15 December 2016

The National Trust of Australia (NSW) makes the following comments on the Stage 2 Development Application for tourist and visitor accommodation at the Lands and Education Buildings (SSD 7484).

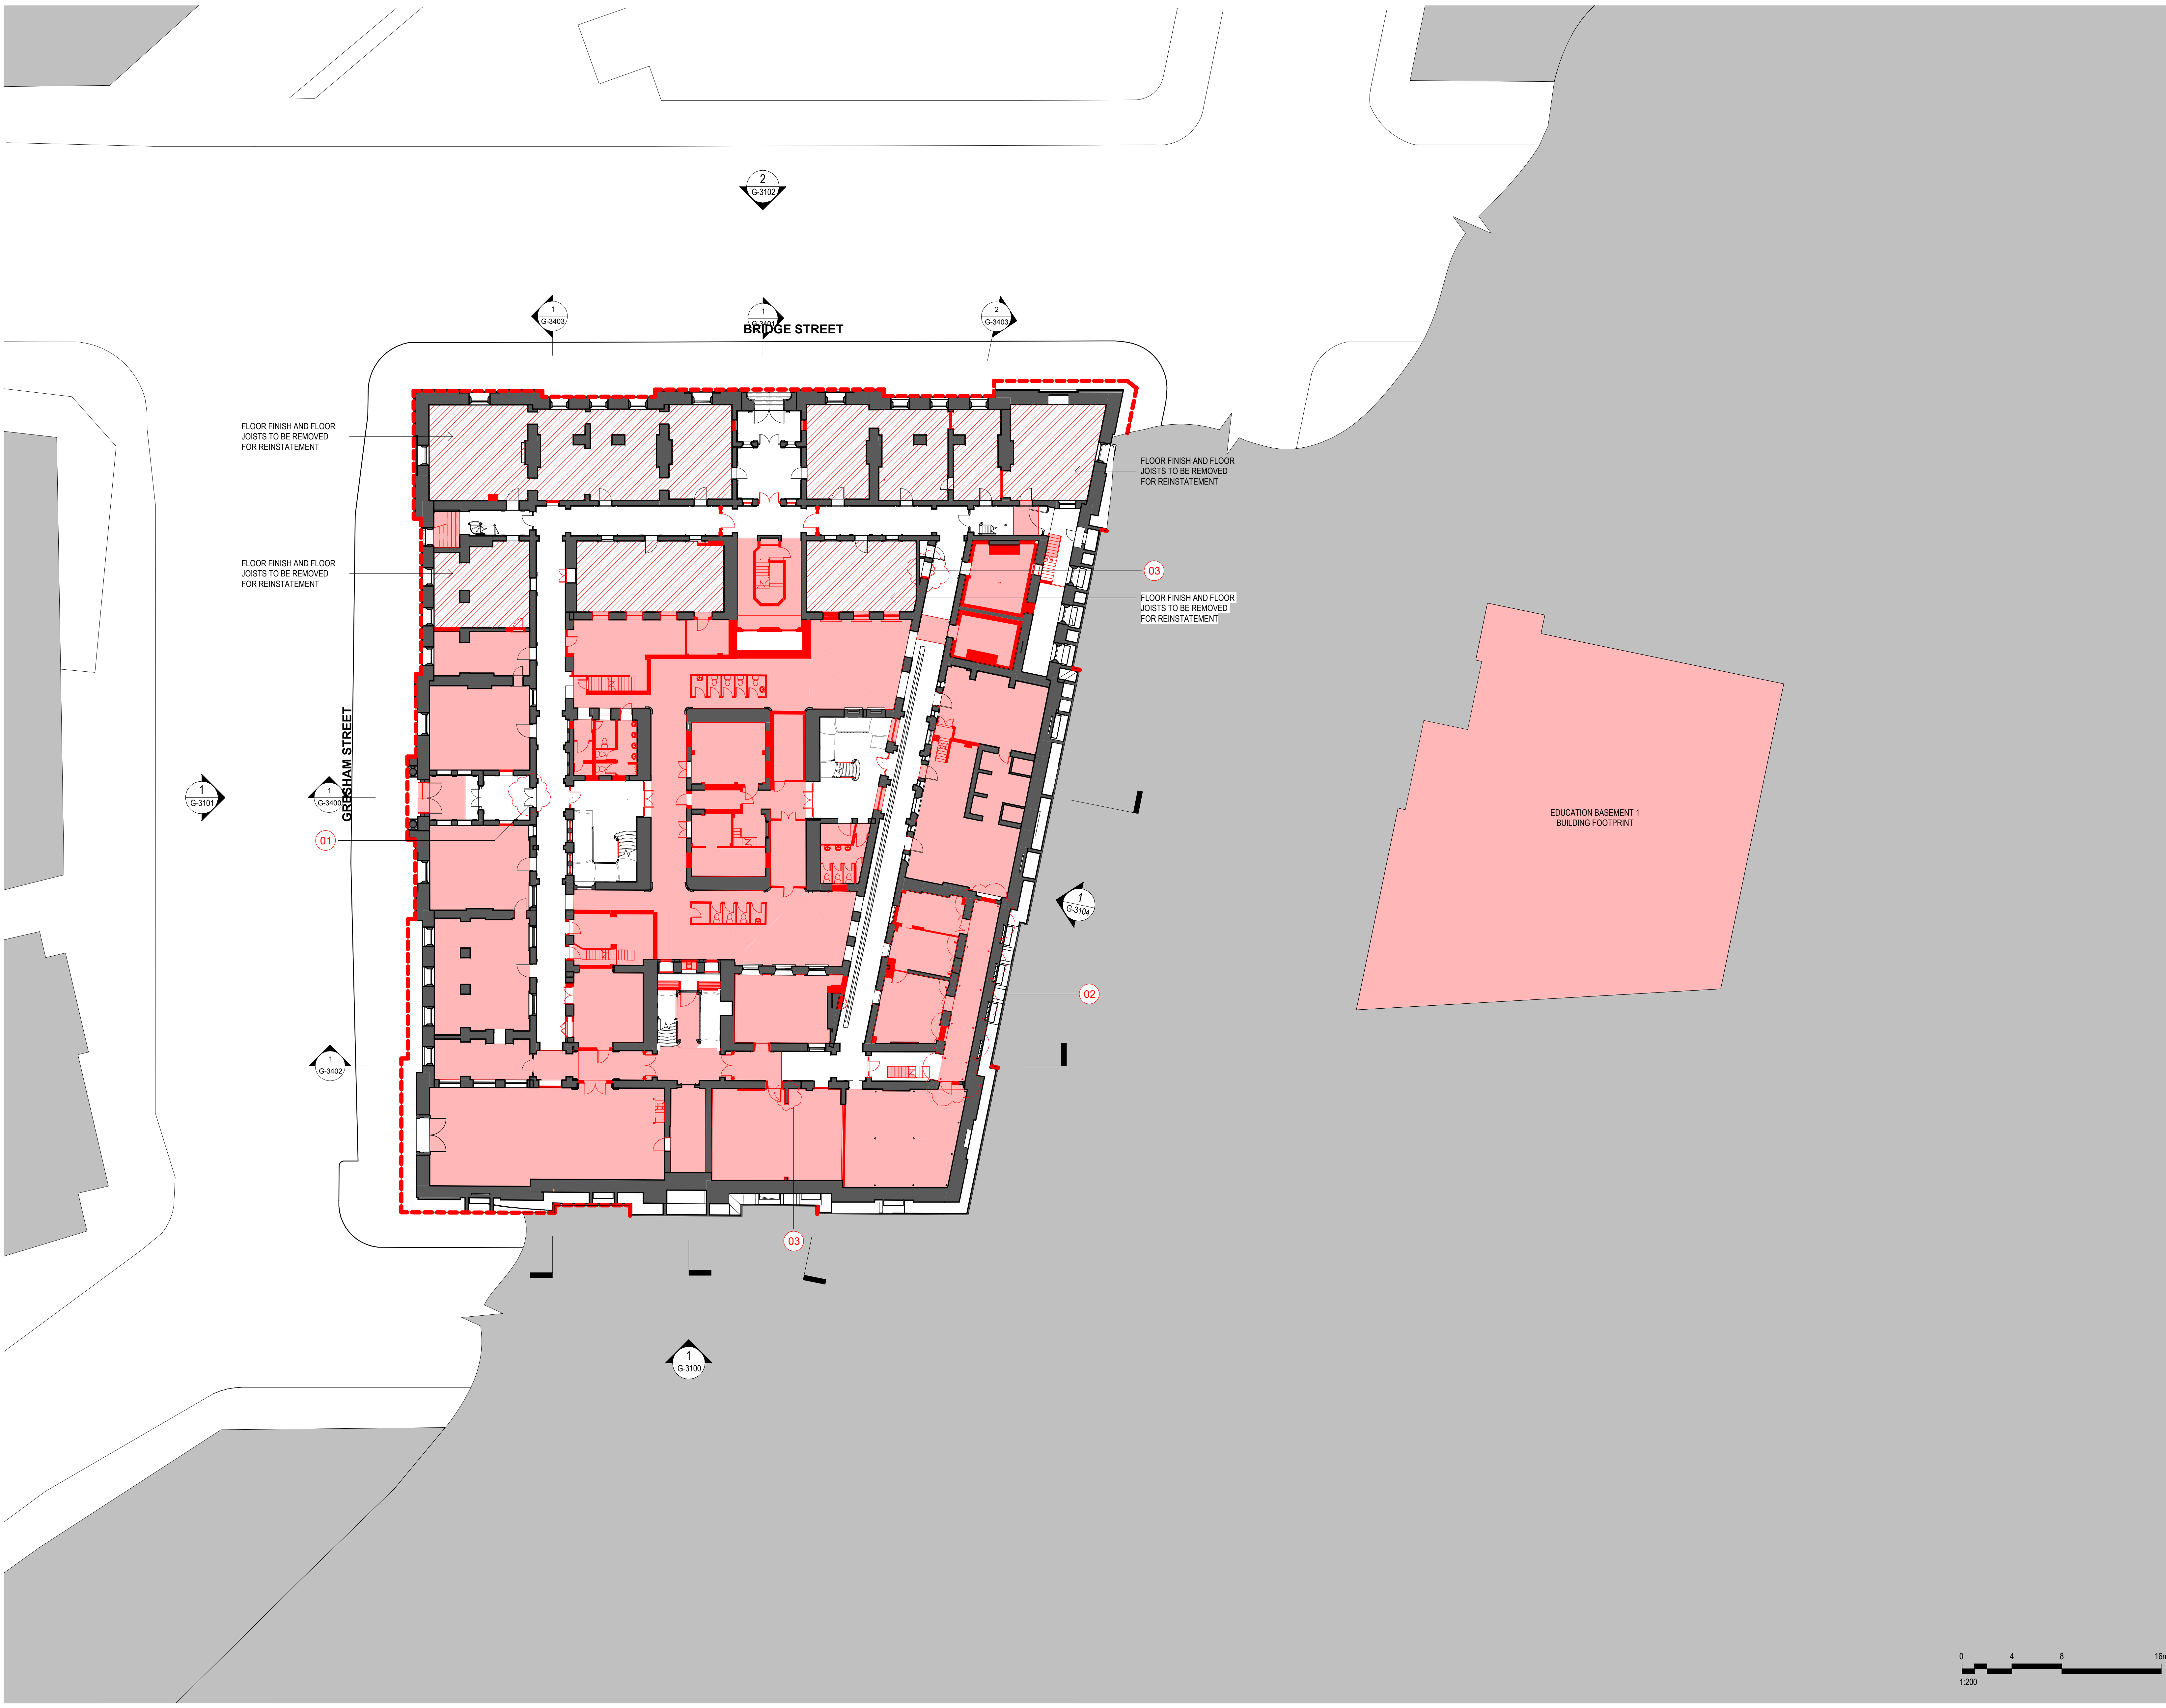
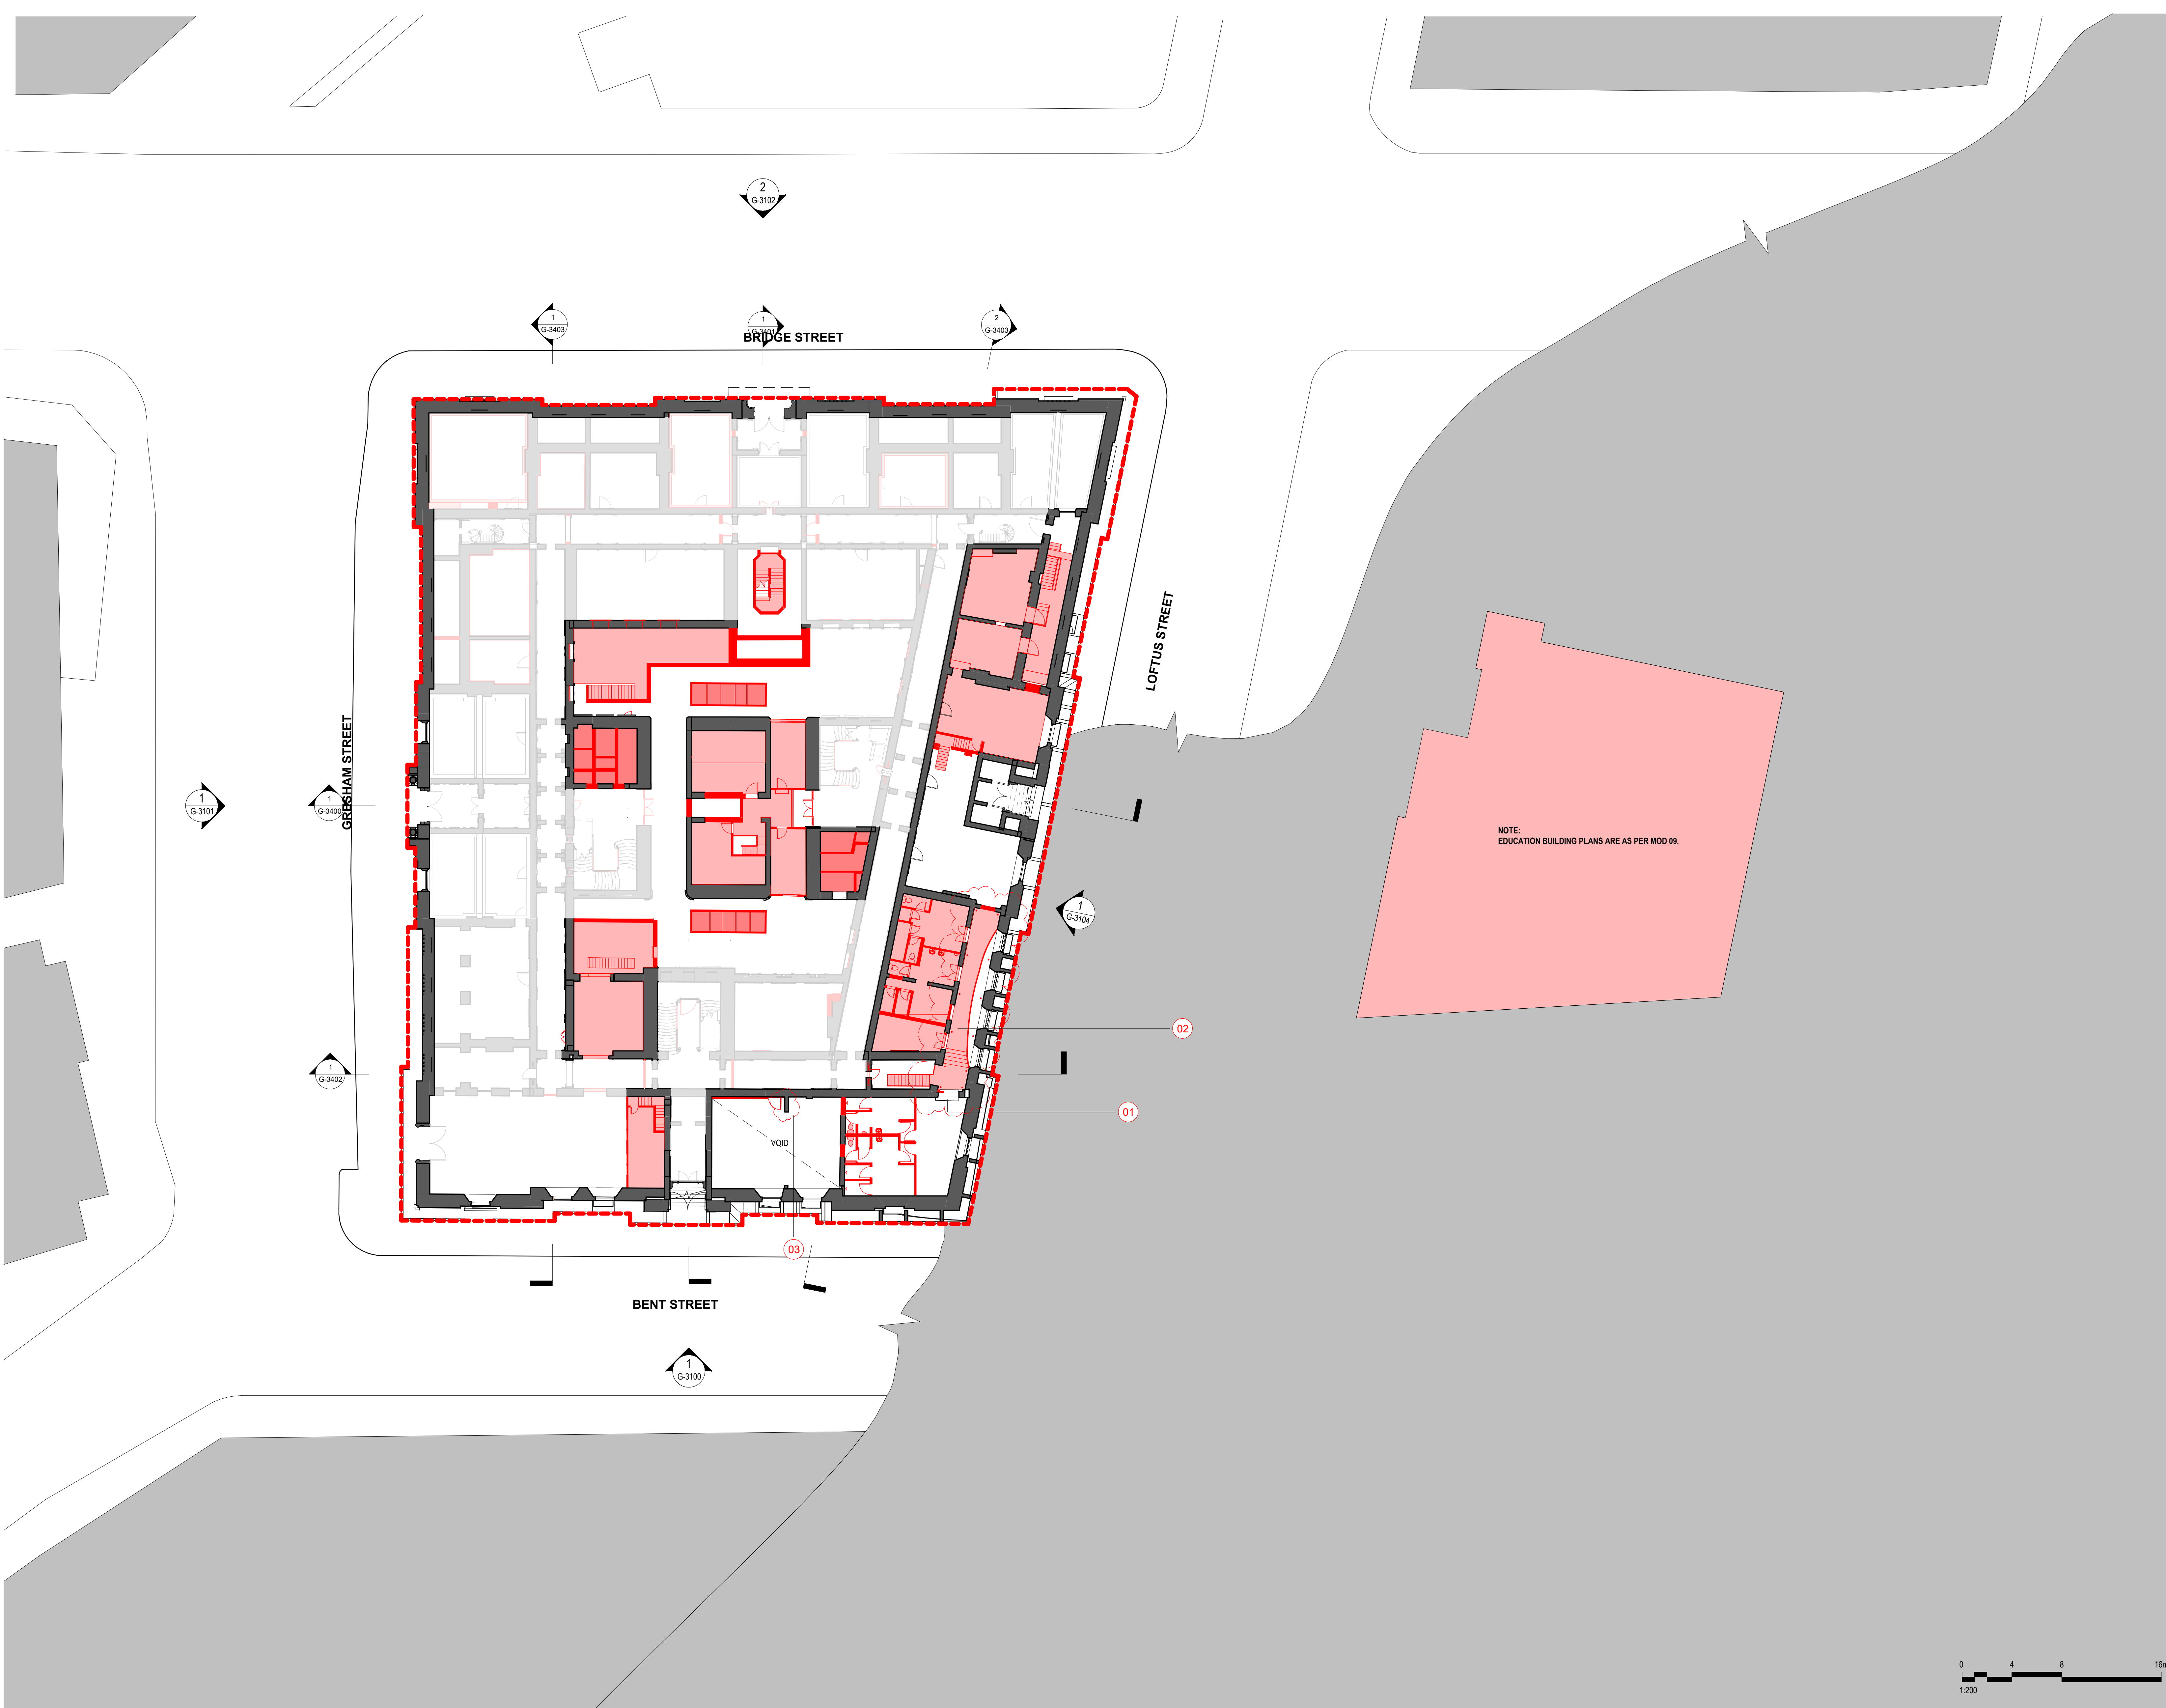
- The National Trust strongly objects to interventions that will adapt the ground level, off Bent Street, as the main hotel guest entry to the Lands Building. The main, historical entry to this building is from Bridge Street, opposite the Obelisk in Macquarie Place from which all distances are measured in NSW - an intrinsic part of the Lands Department Building's significance.

The National Trust strongly objects to interventions that will adapt the ground level, off Bent Street, as the main hotel guest entry to the Lands Building. The main historical entry to this building is from Bridge Street, opposite the Obelisk in Macquarie Place from which all distances are measured in NSW - an intrinsic part of the Lands Department Building’s significance.

The Survey benchmark plug in the Bridge Street entrance will have its significance lessened by removing the main entrance to the building from Bridge Street to Bent Street. With the proximity of Circular Quay and the Opera House to the north, surely retention of a significant public pedestrian entrance to this elevation of the building is acceptable in operational terms for a hotel?

The on-grade Gresham Street loading dock is intended to become the major public entrance to the Lower Ground Level. Utilising a former loading dock and the rear entrance as the main entry points to the building risks the original entry becoming irrelevant. The State Library of NSW suffers from the Mitchell Wing no longer being its main entrance and the same fate should not befall the Lands Department Building.
